Lime Down Solar Park – Development Consent Order (DCO) Application

Environment Agency Examination Deadline 7 Response: Comments on documents submitted at Deadline 6 and post hearing submissions

Drawing file: published-documents / EN010168-001727-6.2 ES Volume 2 Figure 11-3 Lime Down C1 Fluvial and Surface Water Flood Risk Map (Rev 2).pdf

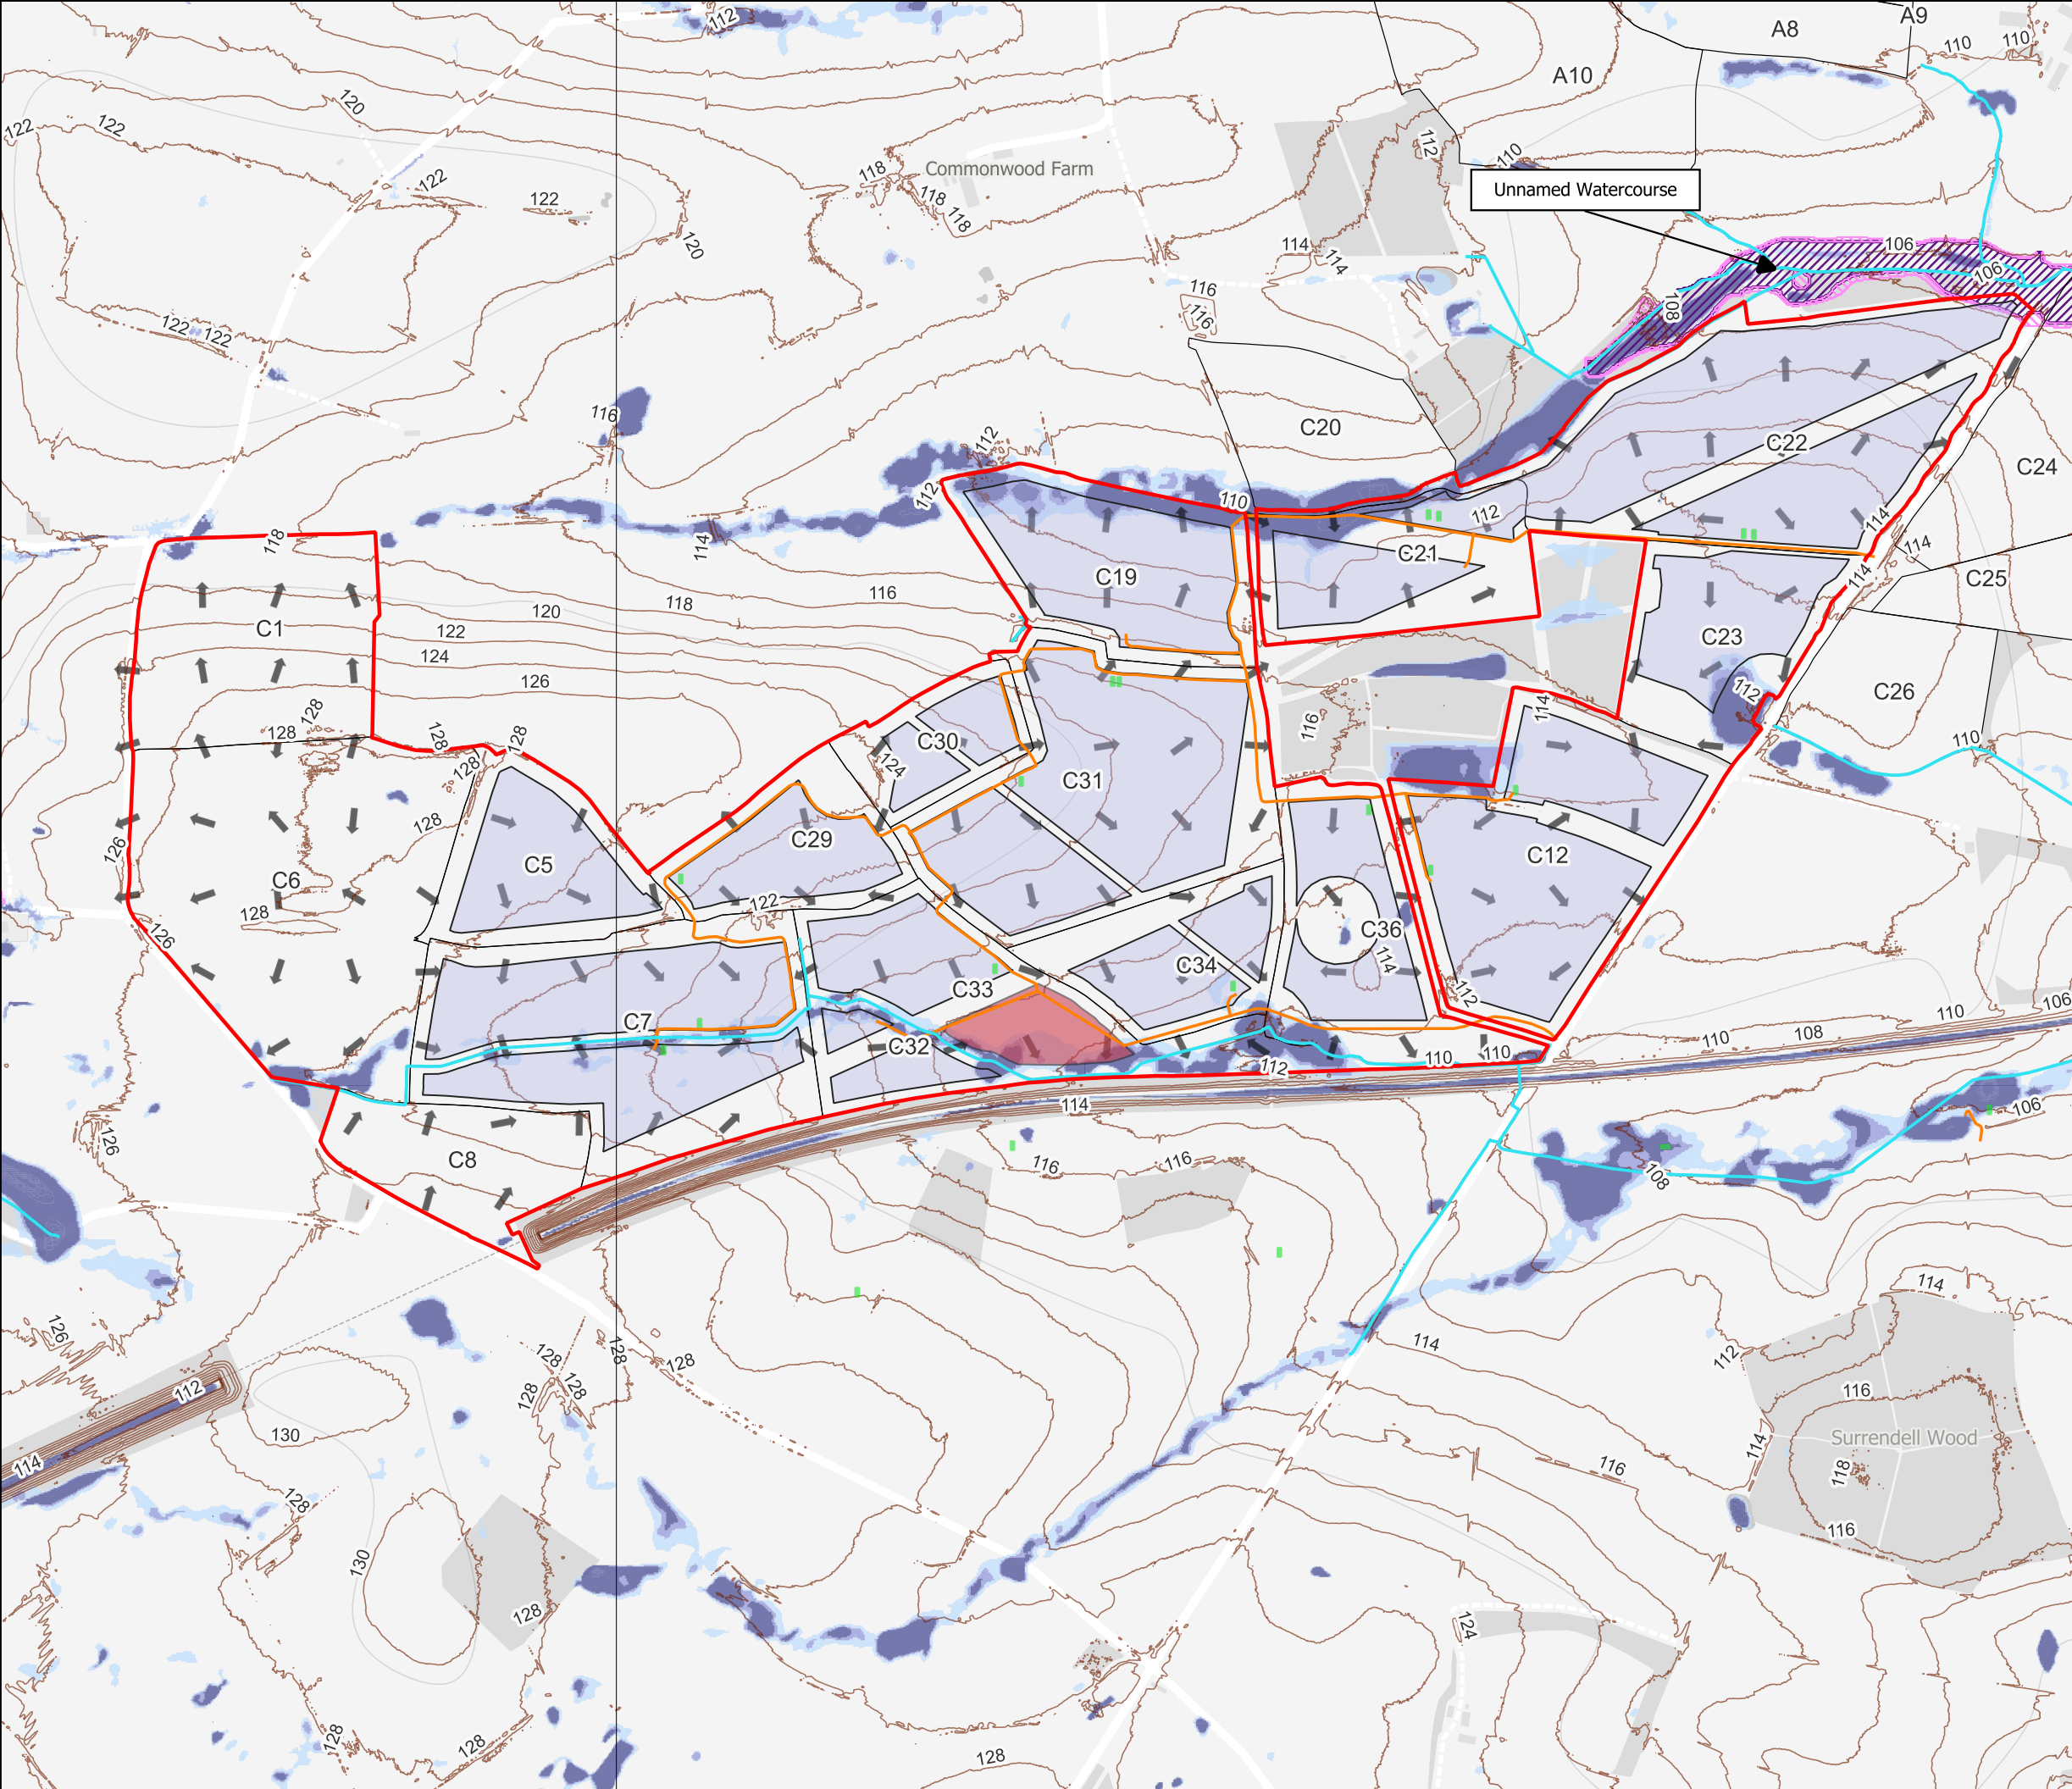
Action 13 Applicant and the EA To update their SoCG: - To reflect the hearing discussion about the hydraulic modelling for the Gauze Brook - To reflect the conversation regarding the location of the substation in Lime Down C1 to ensure that they have a mechanism for the EA to be consulted at design stage - To show the progress regarding the thermal implications of cables on sensitive groundwater receptors (Water Framework Directive).

EA Deadline 5 response REP5 124	Issue	Topic	Environment Agency Updated Position following Deadline 6 submissions
DCO2.1	Lime Down C1	Mapped Surface Water flow route- review this dataset to ensure that there are no significant changes in flood extent and depth.	Agree We welcome the additional text relating to the Flood Map for Planning Surface Water dataset in the updated Flood Risk Assessment and Outline Drainage Strategy for Lime Down C1 dated August 2026 [REP6-010] . Please note the outstanding issue EA-073 regarding compensatory flood storage.
FHW2.8	Outline Construction Environmental Management Plan	Groundwater Monitoring Plan- consultation and reporting	Agree The Outline CEMP [REP6-029] has been updated to include details of the groundwater monitoring plan that will be implemented (table 13). It states that the Environment Agency will be consulted on the monitoring strategy.
